**FINAL DRAINAGE REPORT
FOR
STERLING RANCH FILING NO. 5**

December 2023

Project No. 25188.16

PCD Filing No: XX-XXX ← SF241

SWALE SECTION DP1  
SCALE: 1"=3'

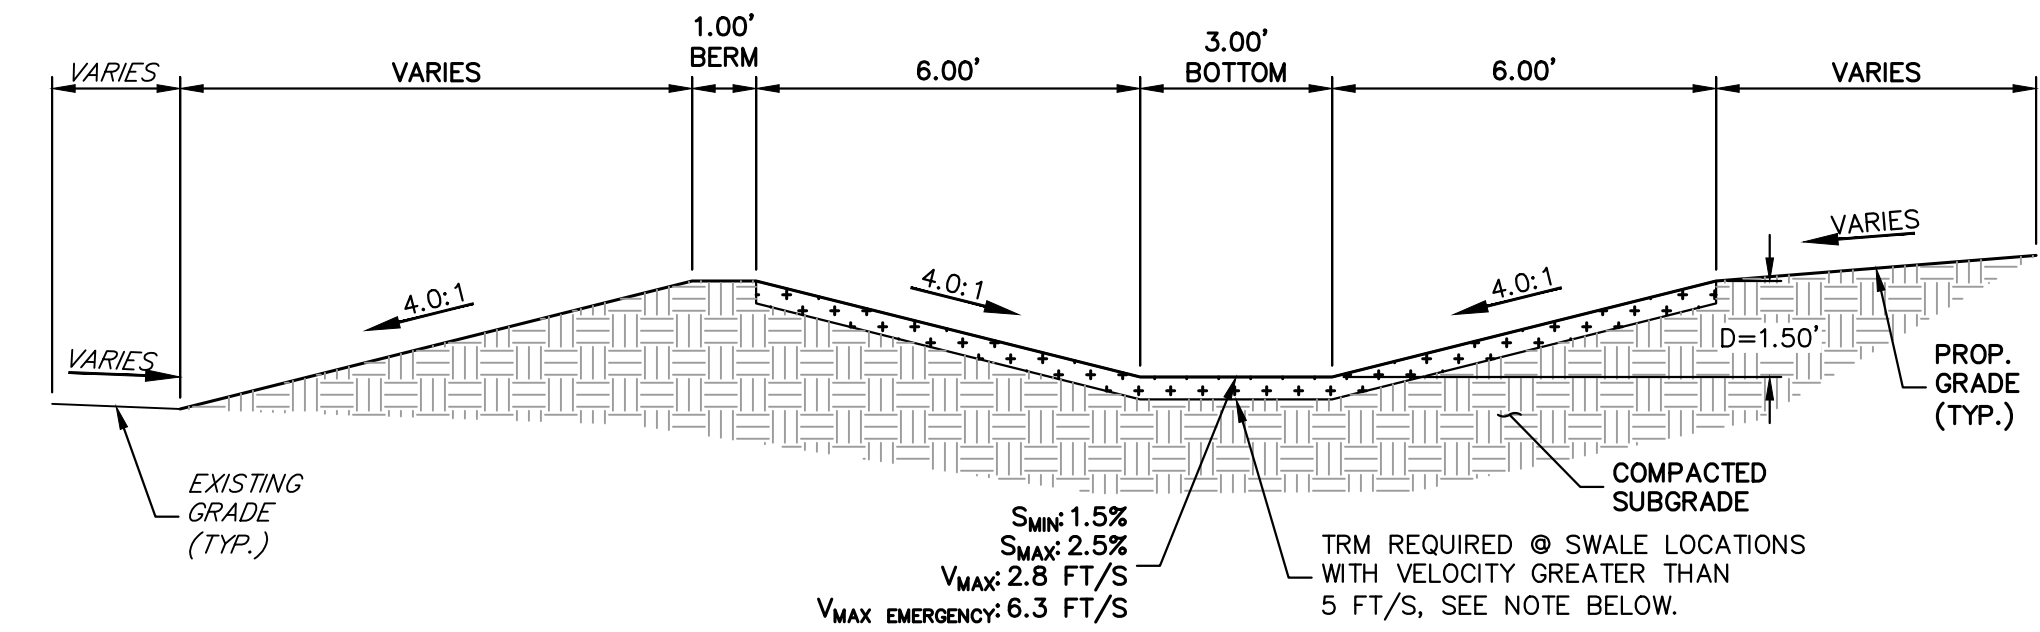
Provide analysis of swale carrying overflow of 62.5 cfs
